Evaluation of the proposed AMEP Regulated Tidal Exchange at Cherry Cobb Sands

**Roger Morris
Bright Angel Coastal Consultants Ltd**

30 August 2012

Figure 28-1 Cherry Cobb Sands site layout

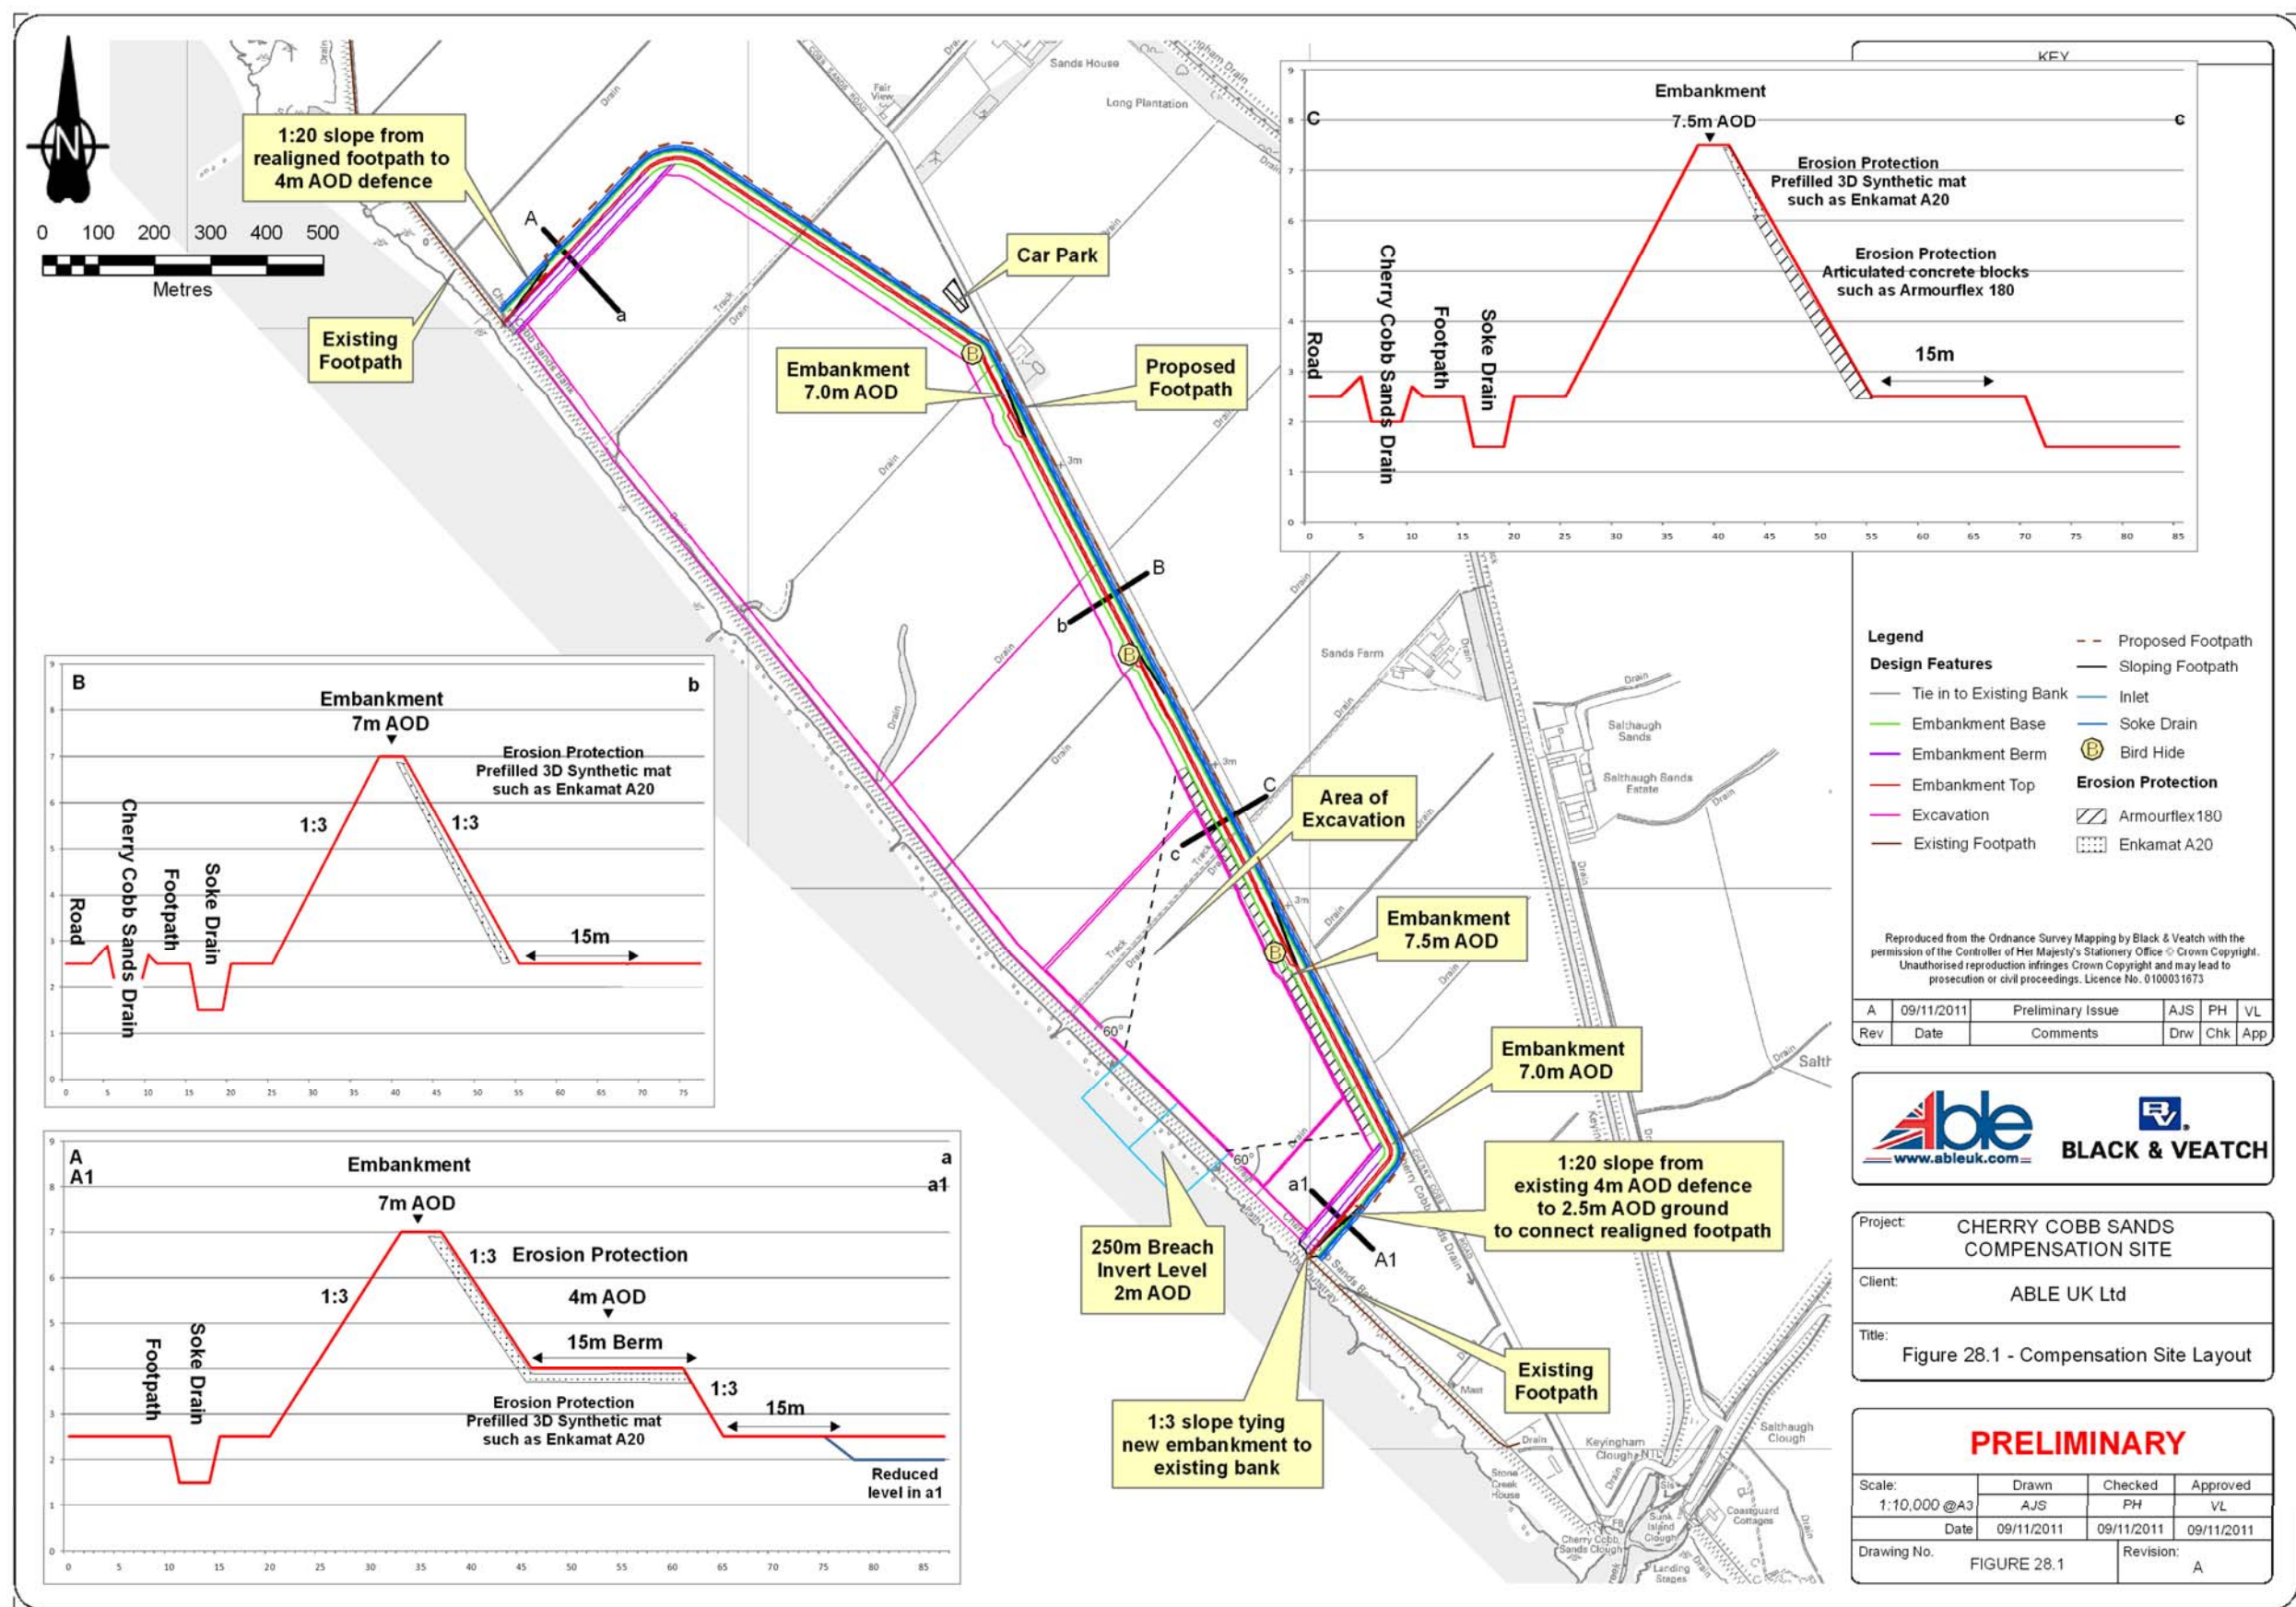
- 1.4. A conceptual design is provided in which three compartments for Regulated Tidal Exchange appear to be supplied with tidal water through a breach at the eastern end of the managed realignment site. This design is accompanied by an extensive report of sedimentation within Paull Holme Strays managed realignment site. Whilst there are parallels between these two sites, it is suggested in this analysis that closer attention should be paid to the process of warping that was formerly employed around the Humber Estuary to improve soil fertility.

- 3.4. Regulated Tidal Exchange differs in several respects, but these are unlikely to give any assurance that a similar outcome will not occur.
- 3.4.1. Firstly, the arrangement of the sluices is such that water will drain more rapidly than during warping. This means that in some localised areas there will be scour, especially in the vicinity of the sluices. This means that the topography of the Regulated Tidal Exchange will differ from a warped site.

- 3.5. As the managed realignment site adjacent to the Regulated Tidal Exchange fills with sediment, it can be anticipated that the channel through the site will be maintained to some degree by the flushing effects of the Regulated Tidal Exchange, but these effects will diminish as warping reduces the volume in the basins. Bearing in mind Black and Veatch base their sedimentation calculations on the behaviour of Paull Holme Strays managed realignment site, the assumption that this offers an adequate model appears to require additional testing. Sediment within settling basins formed by Regulated Tidal Exchange will behave differently, not least because there is less scope for re-suspension because wind-driven waves will be limited by the size of the basins.

- 4.2. Warping is generally only practised in locations where there are high levels of suspended sediment or at times of year when suspended sediment levels are high (fertility in the Nile valley would have been maintained by similar but less controlled processes). Consequently, the development of a Regulated Tidal Exchange in an estuary where warping was so extensively practised might be regarded as unwise, as the site in question can be expected to warp up rapidly.

- 4.3. Any predictions of rates of sedimentation are subject to great uncertainty and consequently it is not possible to offer a realistic timeframe for the life of a Regulated Tidal Exchange (RTE) within the Humber Estuary. It can be shown that sedimentation will occur on each occasion that tidal water is allowed into the RTE basin. However, levels of deposition will be dependent upon the levels of suspended sediment in the water column. Suspended sediment levels are greatly increased during periods of high winds that cause bigger waves to remobilise sediment from foreshores around the estuary. Consequently, it may be anticipated that more sediment will be imported during winter periods when mudflats will need to be regularly exposed in order to maintain bird feeding grounds.

4.4. This means that whilst it is possible that employing Regulated Tidal Exchange may prolong the life of a realignment site as mudflat for an indeterminate period, this cannot be assured. What is more, the extent to which useful mudflat (to feeding Black-tailed Godwits) will be retained is very uncertain. As the RTE basins fill with sediment increasingly limited areas of muddy habitat will exist and this may be expected to further limit the numbers of birds that can be supported. Consequently, Regulated Tidal Exchange cannot be regarded as a viable way of *permanently* offsetting the loss of functionality on the mudflats at the AMEP site within the Humber Estuary.
